# Comments for Planning Application 21/03215/DOM

Application Number: 21/03215/DOM

Address: Westfield Mill Lane Fishbourne PO19 3JN

Proposal: Remodel and alteration works including first floor rear extension and front and rear dormer windows to existing roof accommodation

CLIENT	Mr & Mrs H Hillary	DRAWING	002 Existing & Proposed Elevations	
SITE	Westfield, Mill Lane, Fishbourne	DATE	12 10 21	AUTHOR AH
PROJECT	Proposed Extensions & Alterations	SCALE	1: 100 @ A3	STATUS PL

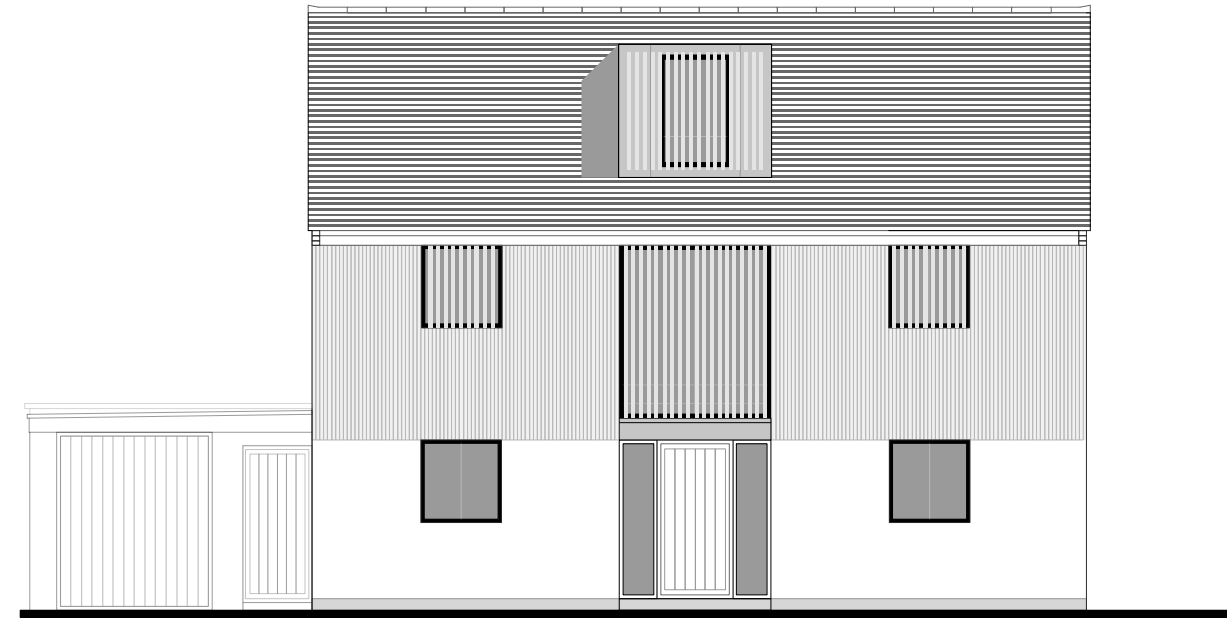
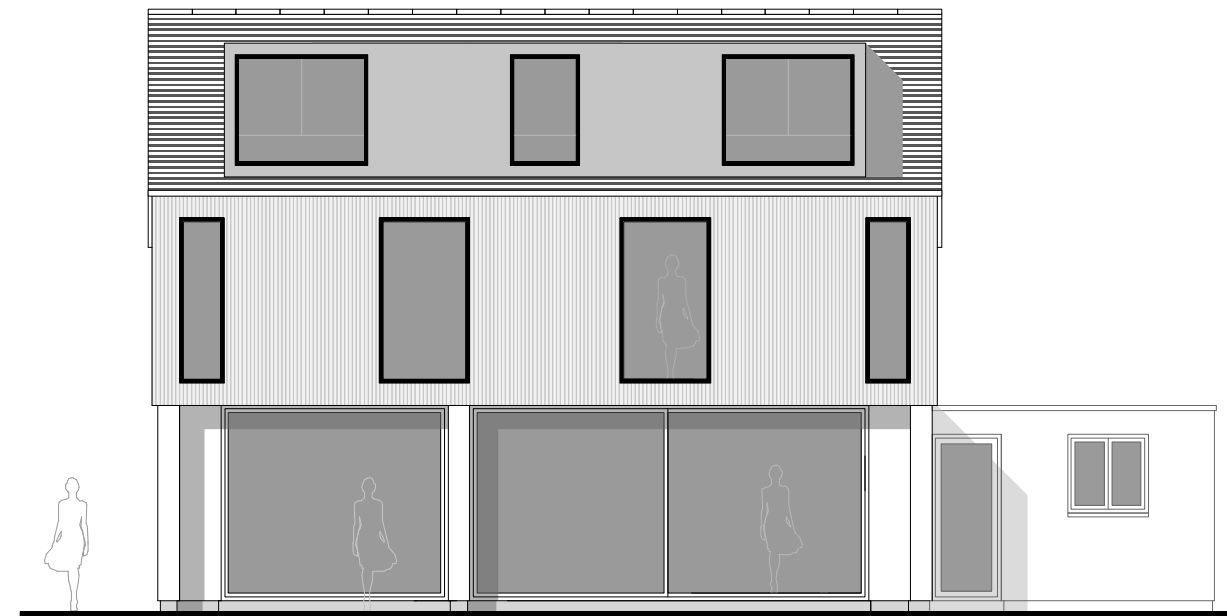
Comment: I live approx 35 metres on the east side of Westfield, and feel that the proposed extension and the new dormer windows to this house will be over development of this property. The house is situated slightly above Mill Lane and the enlarged profile will affect the light on surrounding properties.

The dormer windows will over look the main bedroom and sitting room of my house and surrounding gardens in the neighbourhood.

I would be grateful if the plan could be reduced in keeping with the rest of the houses in the immediate area.
